Monument Junction West Filing No. 1
Construction Documents Review (Streets, Storm Sewer and Final Drainage Report
Review) - Submittal 2

Date:	07/25/2022	Jacobs Engineering Group Inc.
Project no:	A.PN.CI.067	6312 S. Fiddlers Green Circle
Attention:	Debbie Flynn, Planner II	Suite 300N
Company:	Town of Monument:	Greenwood Village, CO 80111
Prepared by:	Mark Kitzmiller	United States
		T +1.720.286.2000
		www.jacobs.com

1. "Monument Junction West Filing No. 1 Construction Plan Set," by Classic Consulting, dated June 20, 2022.
2. "Final Drainage Report for Monument Junction West Filing No. 1," by Classic Consulting, dated July 2022.
3. CCES Responses to Submittal 1 review memo. **Note: Per e-mail attached, Jacobs did not have any comments on storm or pond plans.**

N:\130220\DRAWINGS\CONSTRUCTION\04-1-30220-SIGNAGE AND STRIPING\PLAN.dwg, 8/12/2022 11:25:36 AM, 1:1

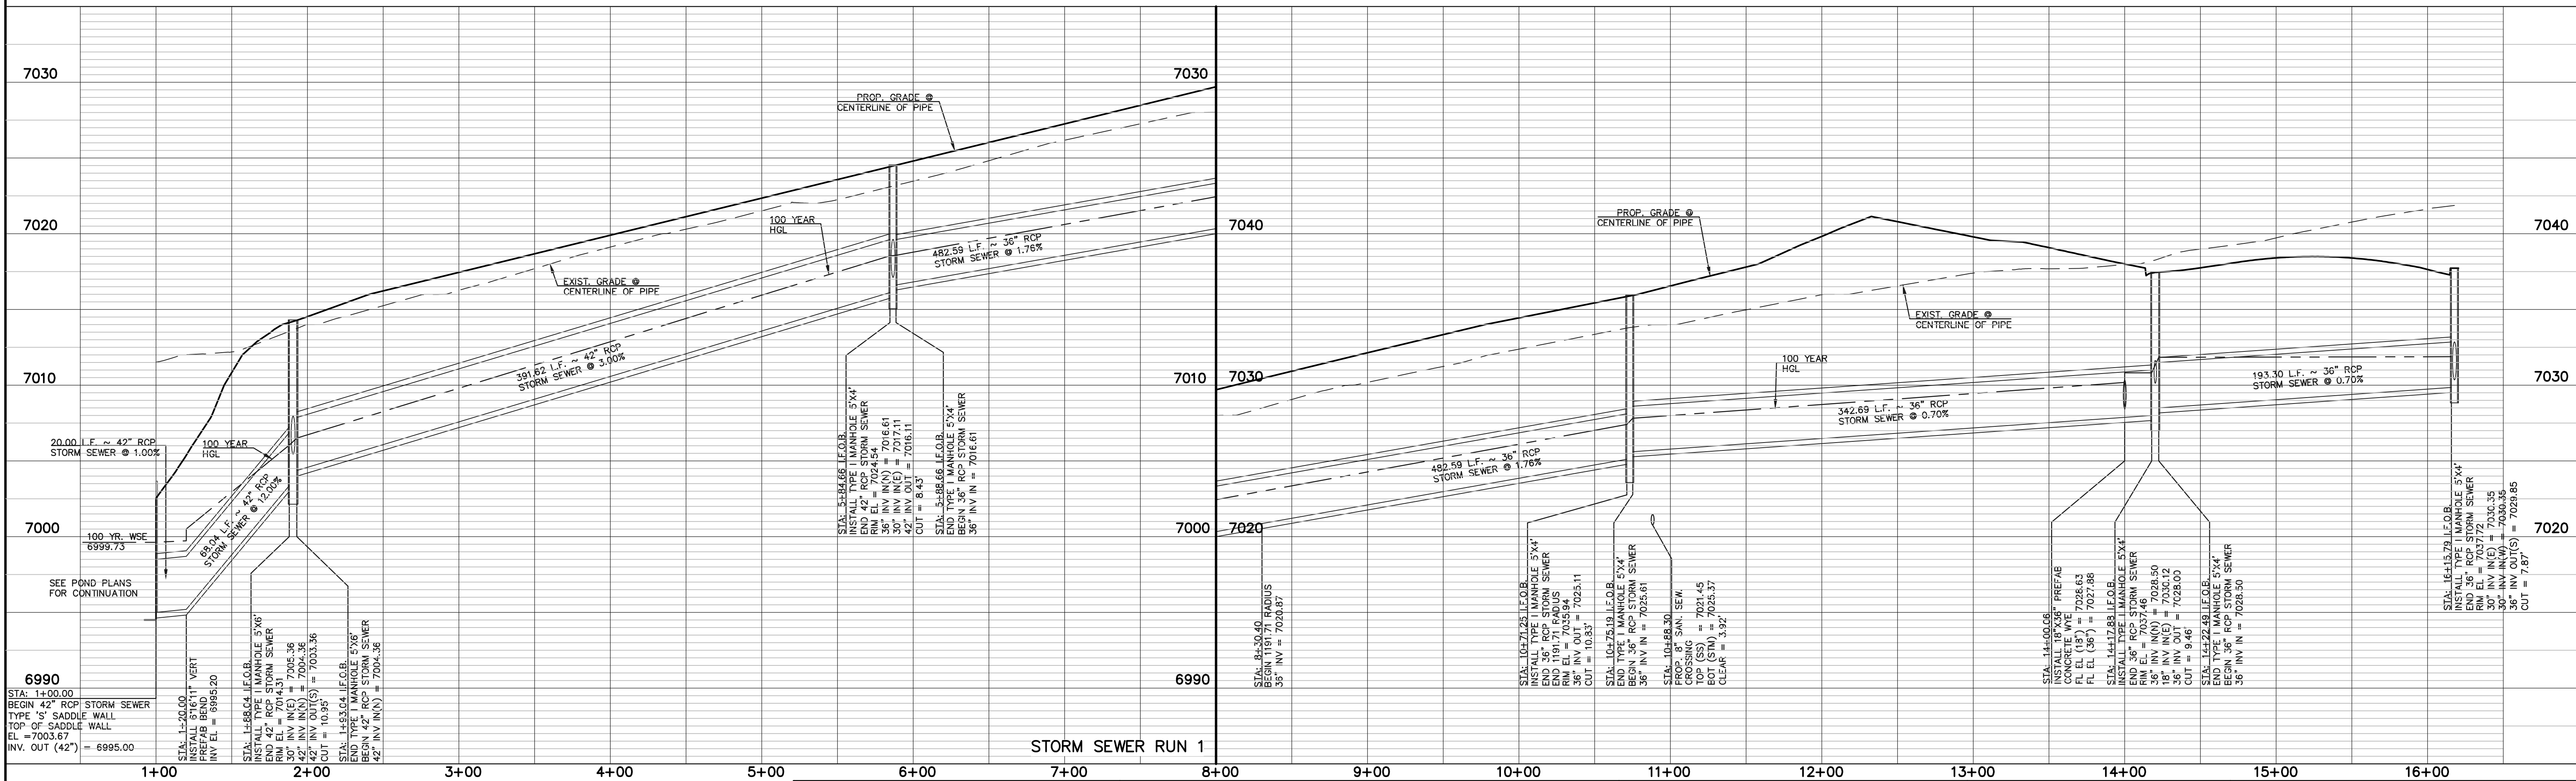
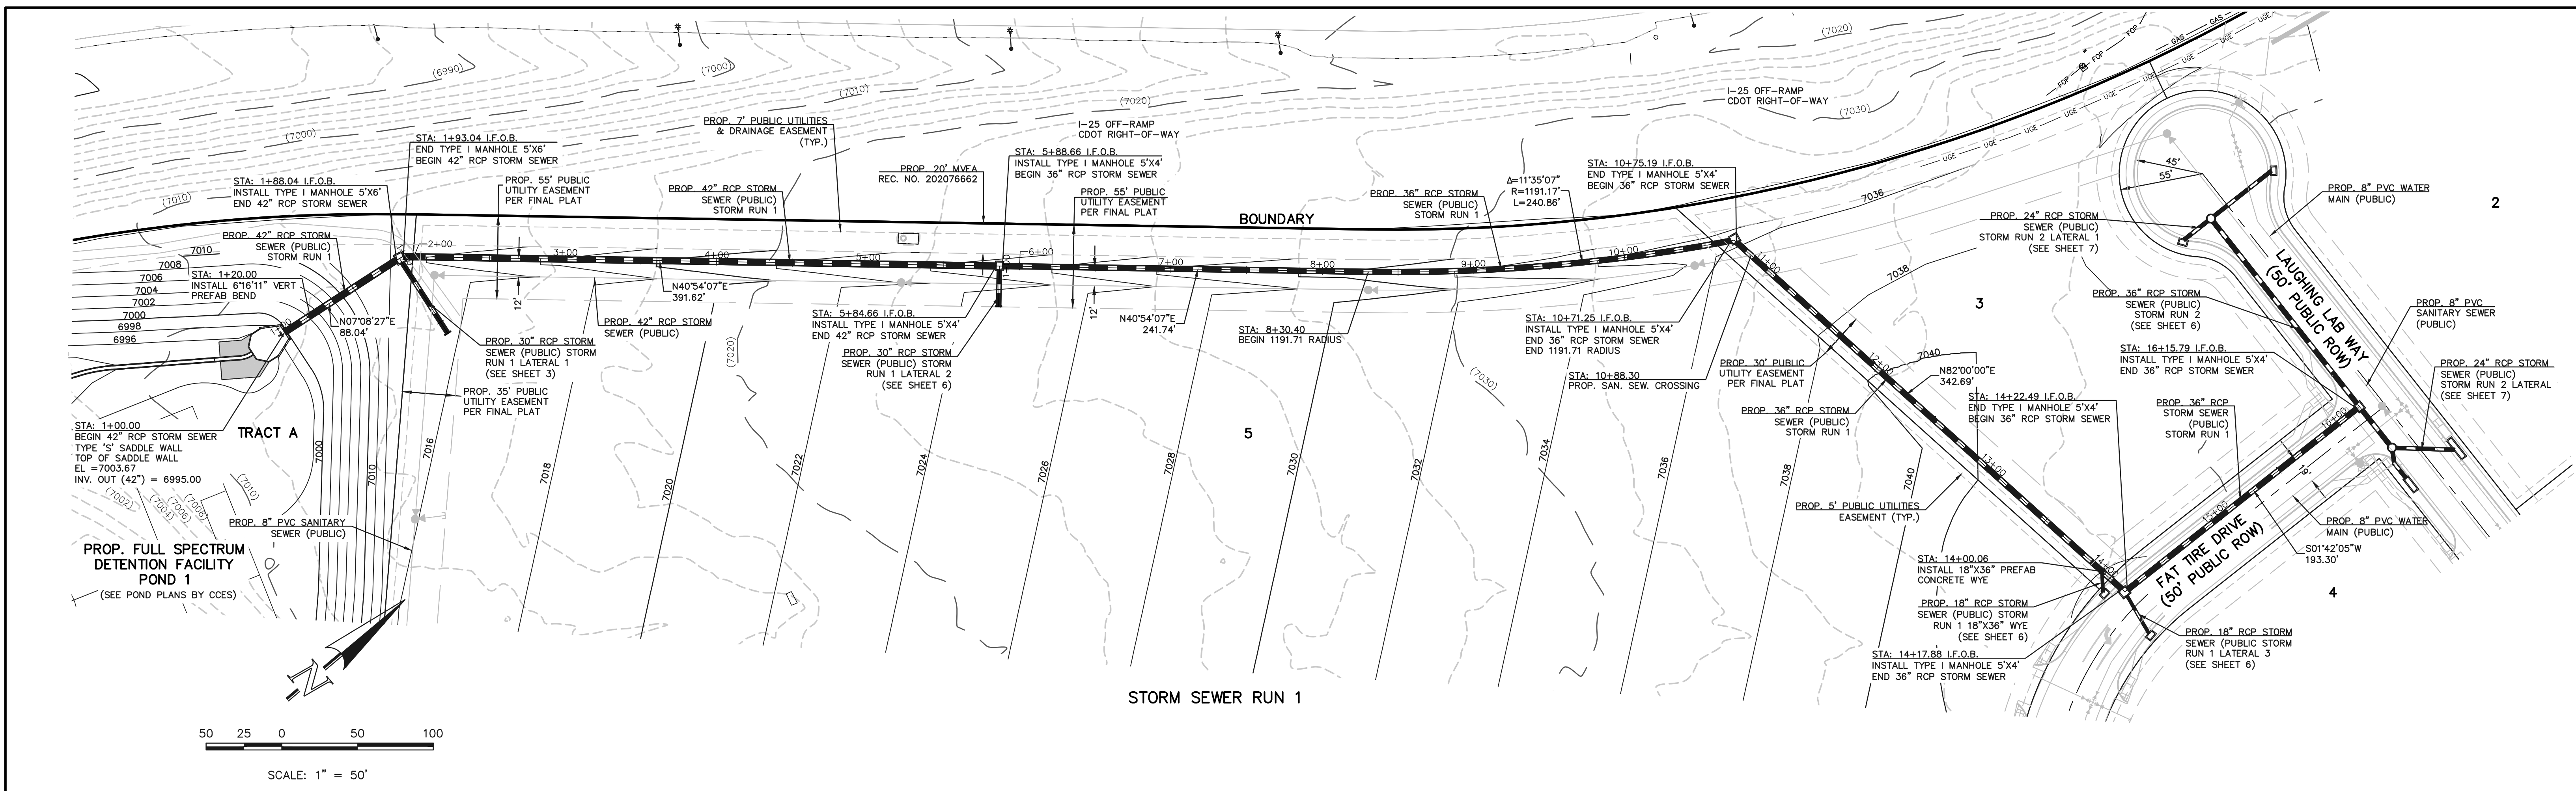
1. The Monument Junction TIS (LSC, Feb 2022) indicates that Fat Tire Dr. (Access B in the TIS) left-turn lane recommended storage be 200' so that LT's do not block the TH/RT vehicles. Has this length been accommodated? It's obvious the striping doesn't accommodate this but perhaps the roadway width does. **Addressed**
2. Add left turn arrows at beginning of left turn lanes, typical. **Addressed**
3. Add 8" before "SOLID" in the proposed solid white channelizing stripe callouts, typical. **Addressed**

4. Add 4" before "SOLID" in the proposed solid double yellow centerline stripe callouts, typical. **Addressed**
5. Add stop bars and crosswalk markings per town standards DT 33 on all roads intersecting with Jackson Creek Pkwy., if not included in those improvement plans. Turn lane striping should extend to stop bars once drawn in. **Partially addressed. Turn lane striping should extend to the stop bars (no gap). Crosswalk lines are to be 24" wide. Revised to 24" wide**

6. Add station and offsets or something to include where striping begins and ends. **Addressed**
7. The sign shown at the end of Oktoberfest Dr. on the barricade does not match the detail or the sign code (R11-2) shown. Please update sign to match detail. Message should be ROAD CLOSED, unless you're letting general traffic (not construction vehicles) past the barricade. **Addressed**

8. The detour sign shown on the barricade detail is not needed. Please remove. **Addressed**
9. **New Comment: add "Town of Monument Standard DT 33 and" to *Note in Striping Legend. Added**

10. **New Comment: Are the parking spaces shown along Oktoberfest Drive part of this submittal? If so, stall dimensions, striping details, etc., should be provided. Added**
